DRB Application No.: 09DRB ~ 70069 Project # 1007303  
 Project Name: \_\_\_\_\_  
 Agent: Michael Eaves Phone No.: 259-5210

**CITY OF ALBUQUERQUE  
PLANNING DEPARTMENT  
March 31, 2010  
DRB Comments**

PROJECT # 1007303

RE: Tract 154-C, MRGCD Map # 32

**PLAT OF  
 LOTS 1, 2 AND 3  
 LA CASTILLA ADDITION**

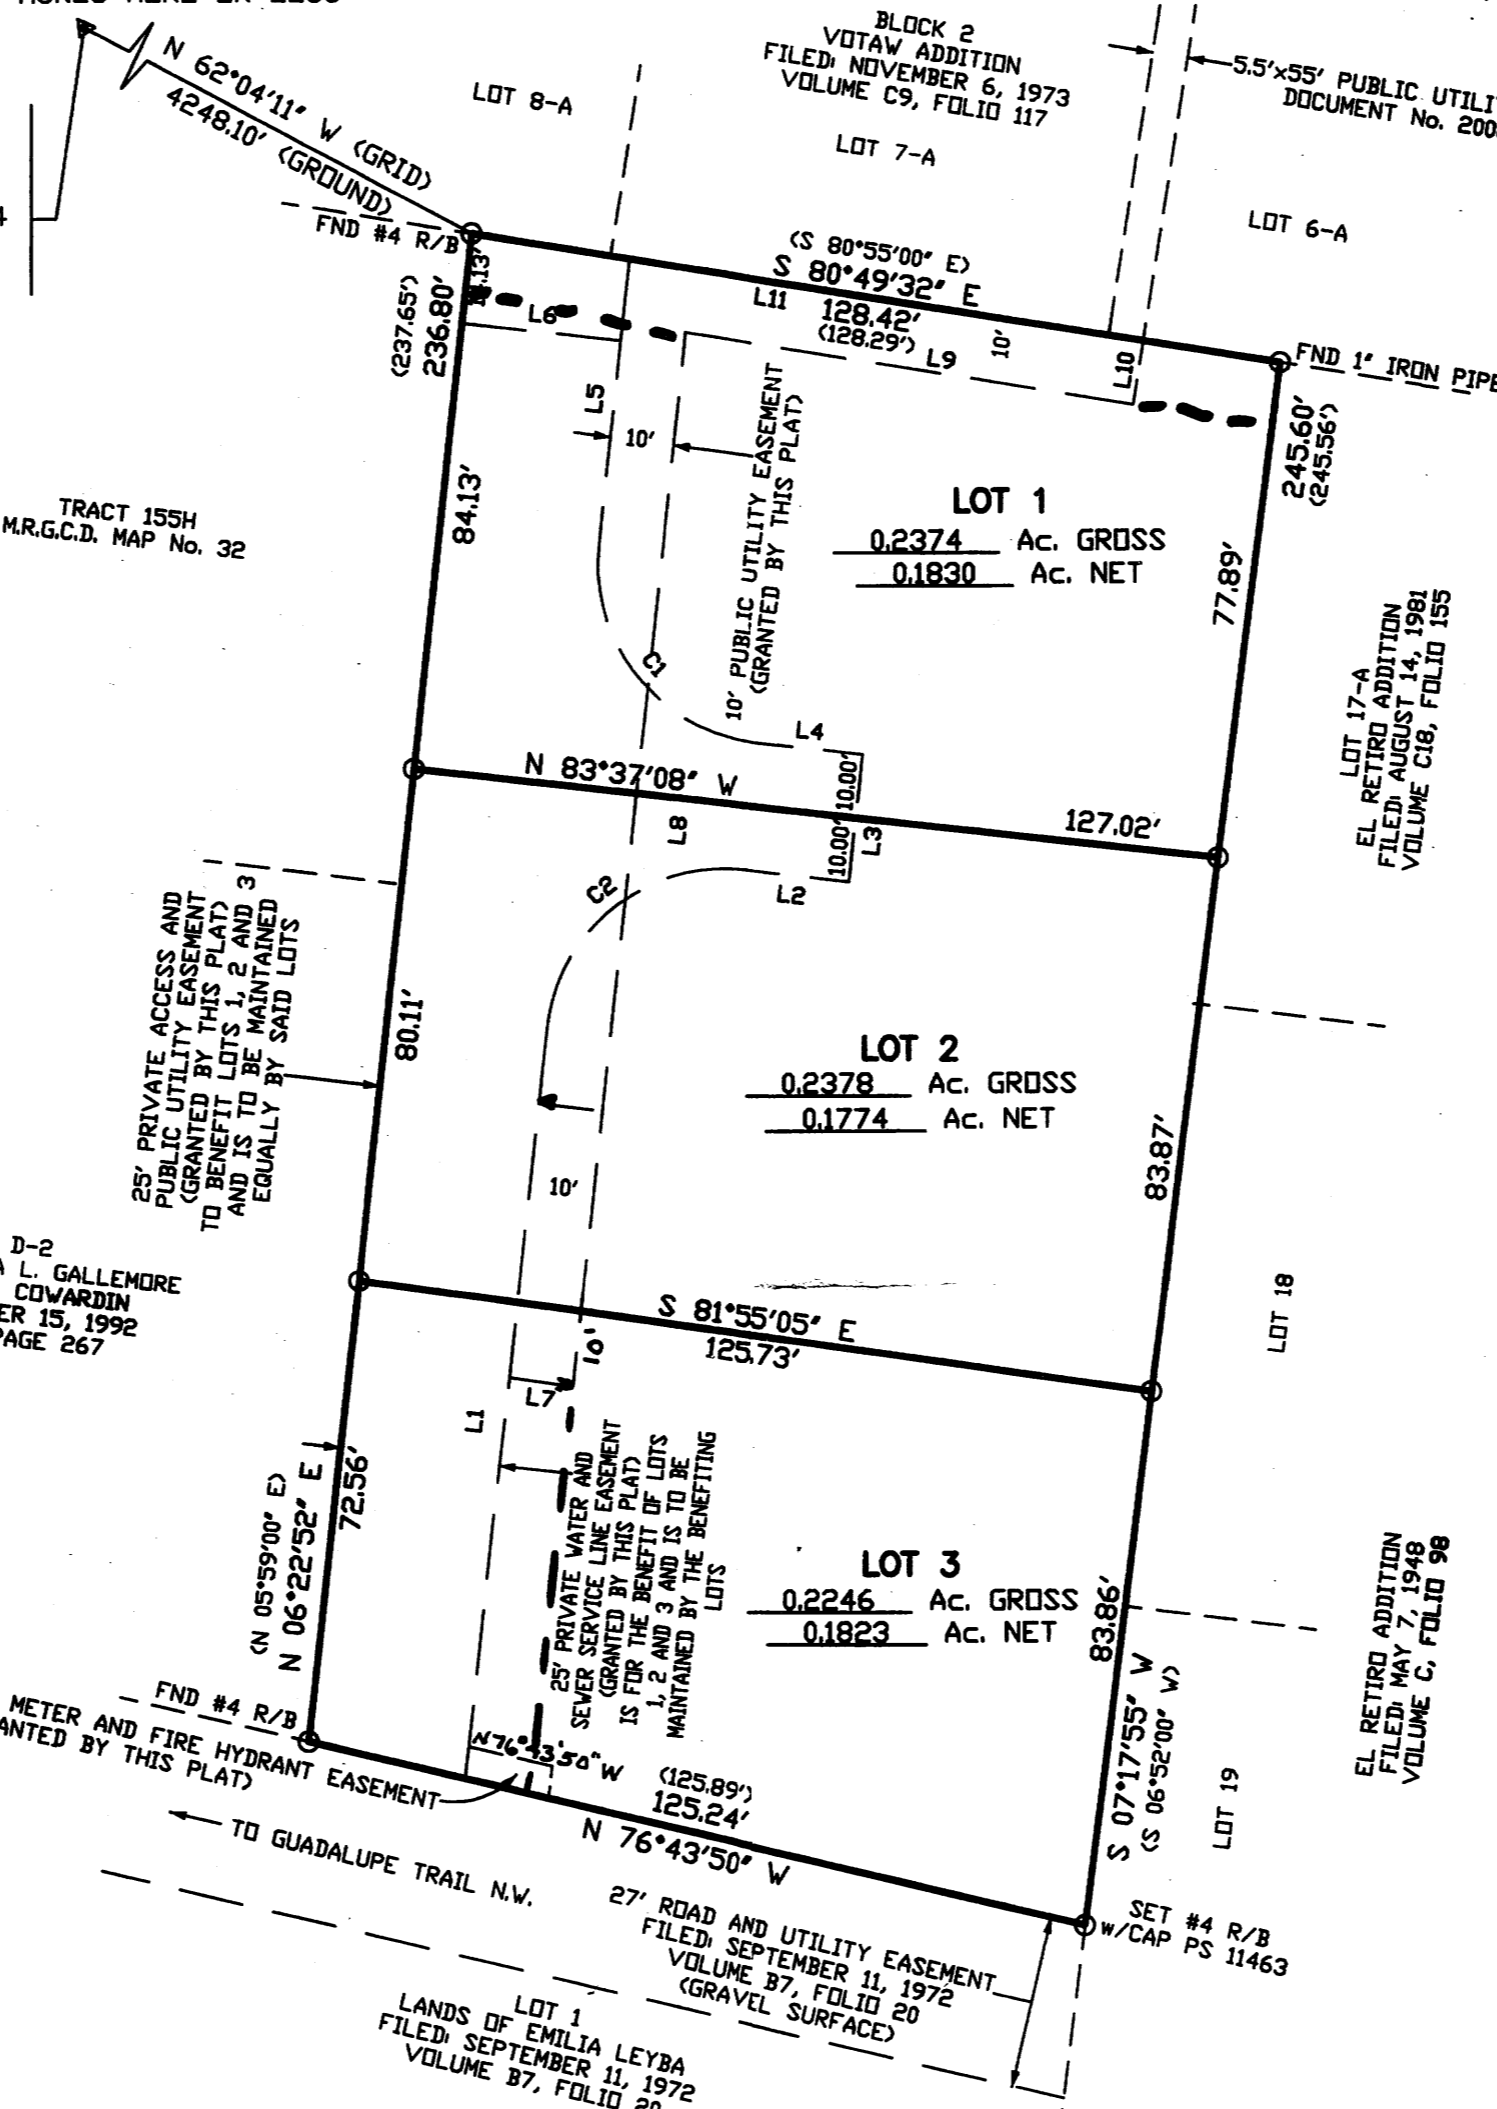
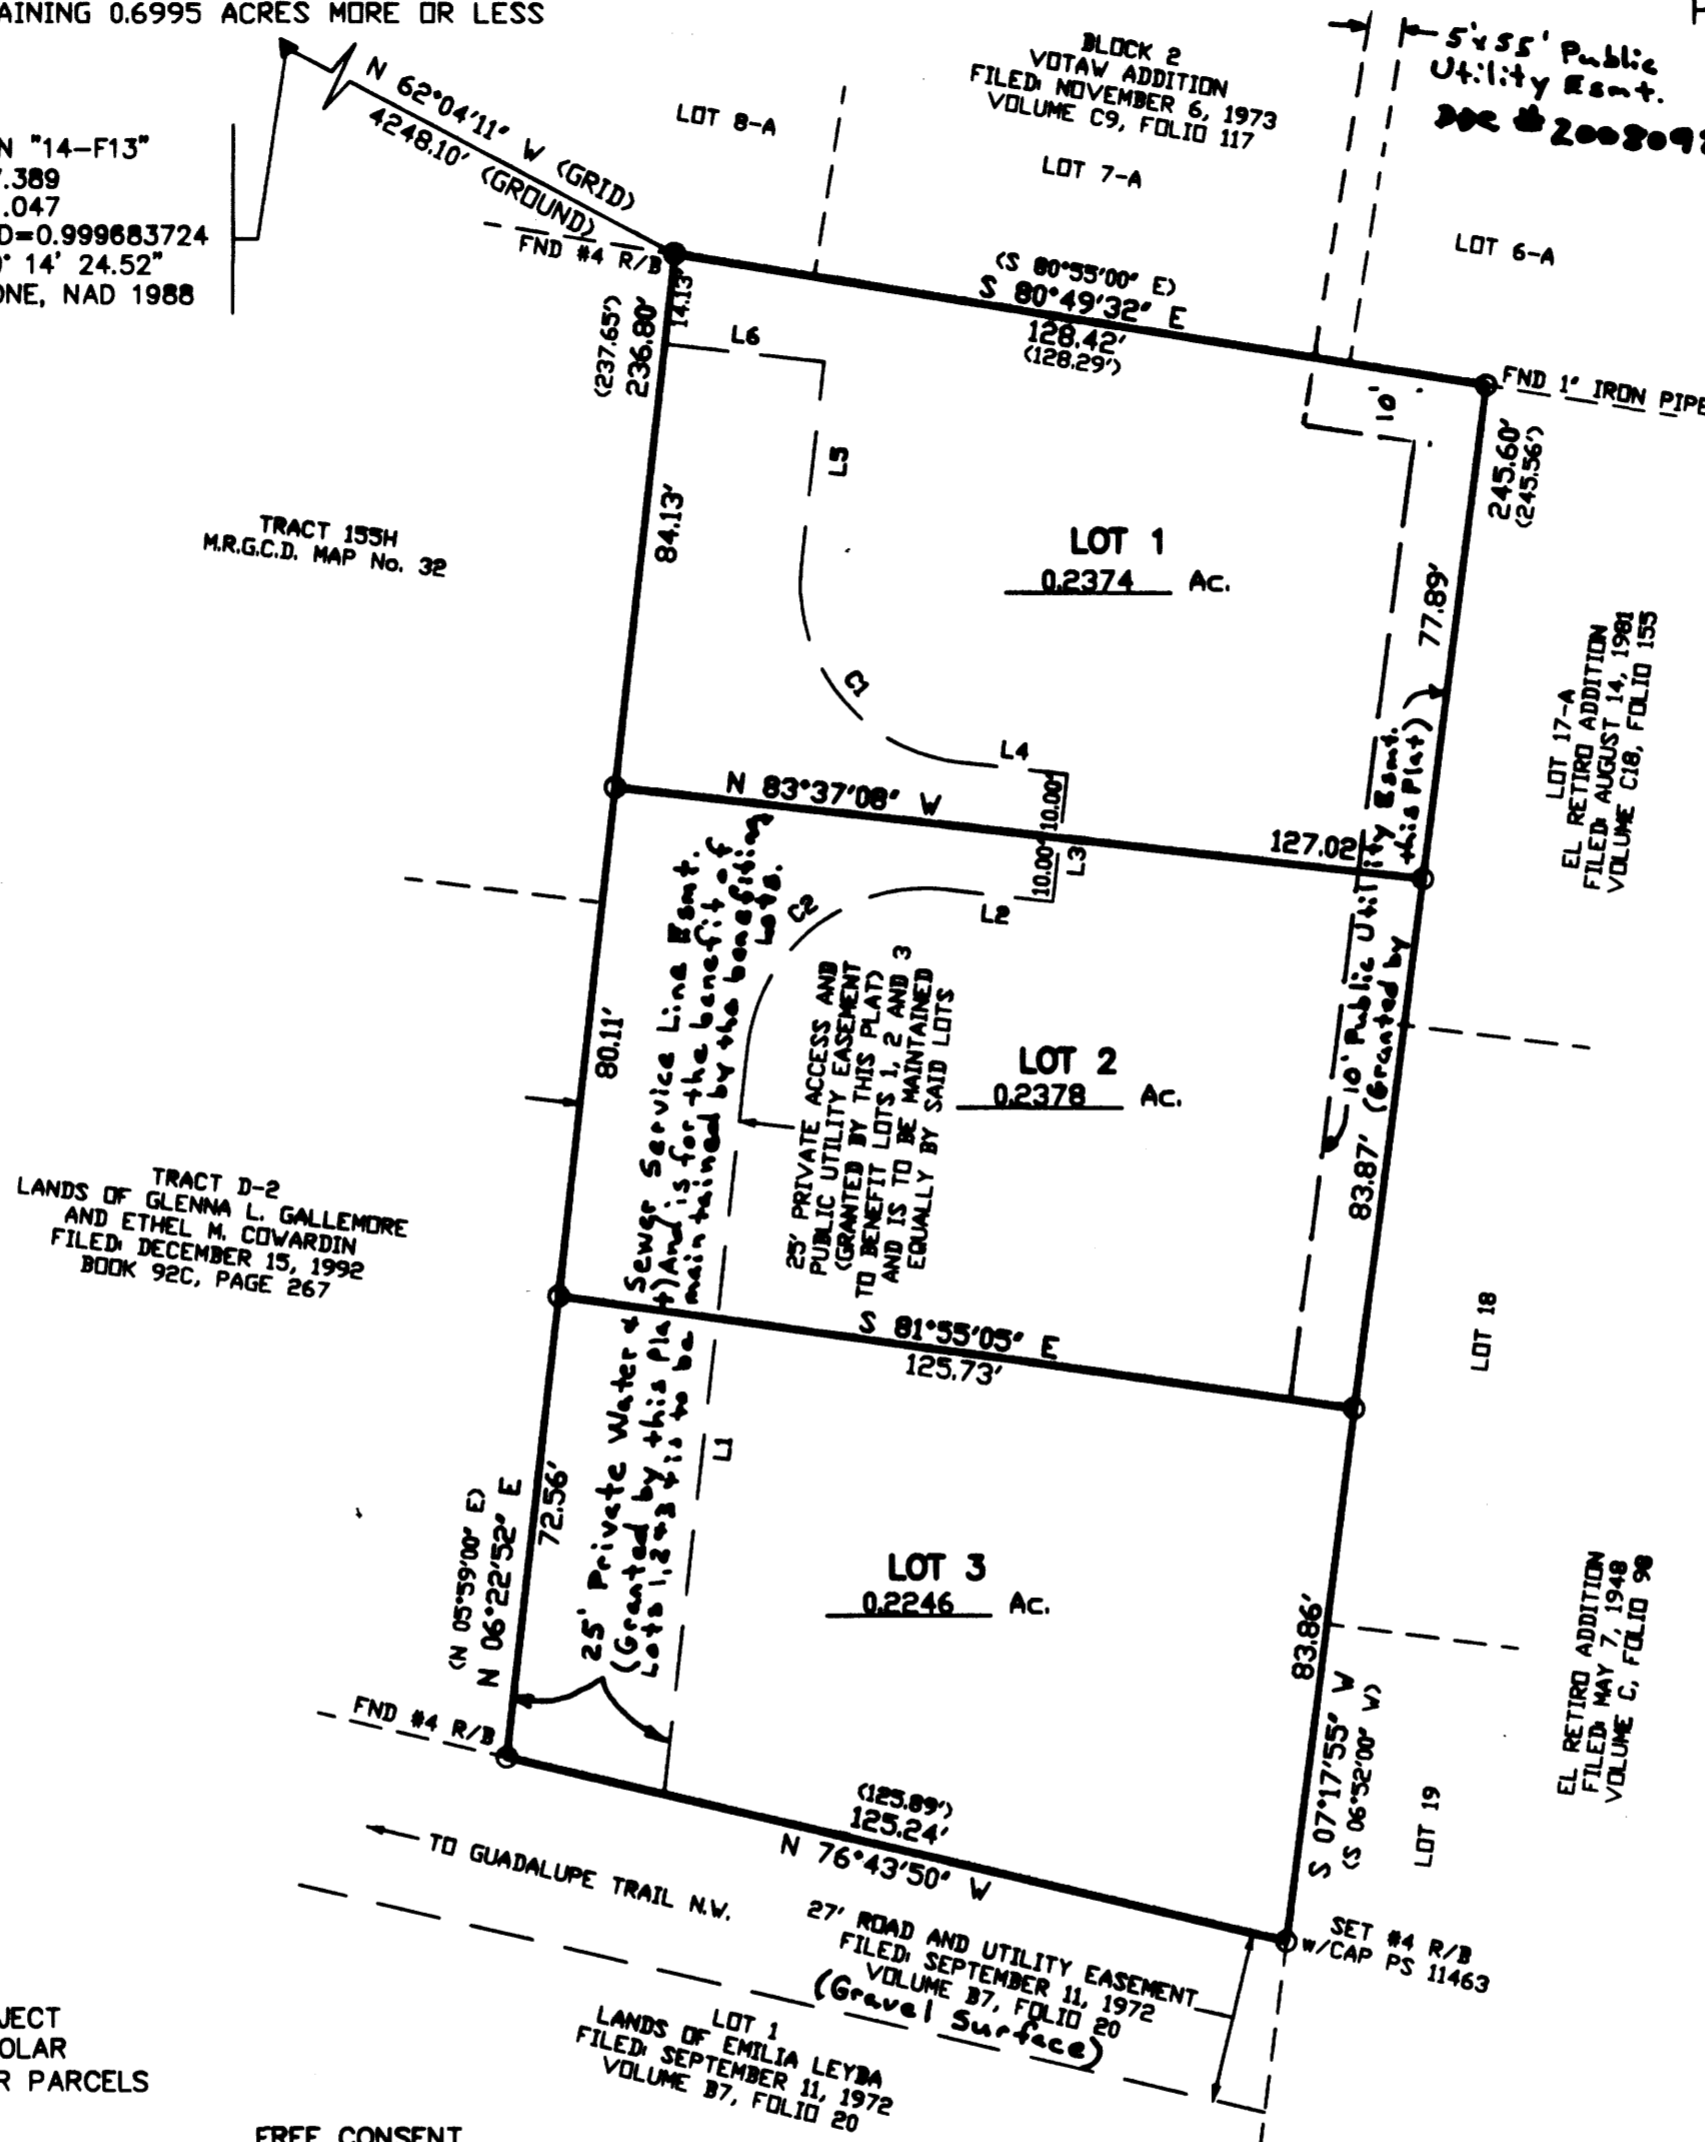
Please provide a copy of the document or plat that grants access rights/ beneficiary status to this property. It appears there are currently 12 lots using this easement, and this plat would increase by two to 14 lots.

1. There must be an Infrastructure List to include public water/sewer line extensions, service connections, and fire hydrant.
2. Plat must include private water/sewer service line easement within the driveway easement.

MICHAEL EAVES agent(s) for LA CASTILLA, LLC request(s) the above action(s) for all or a portion of Lot(s) 154C, zoned R-1, located on GUADALUPE TR NW BETWEEN MONTANO AND GRIEGOS NW containing approximately 0.705 acre(s). (F-14) **PRELIMINARY PLAT WAS APPROVED. FINAL PLAT WAS INDEFINITELY DEFERRED. CONDITION OF FINAL PLAT IS VERIFICATION OF ACCESS EASEMENT TO GUADALUPE TRAIL AND NET LOT AREA CALLED OUT ON PLAT.**

Please provide a copy of the document/ plat that grants access rights/ beneficiary status to this property. Each lot's net area (exclusive of access easement) needs to be noted on the final plat.
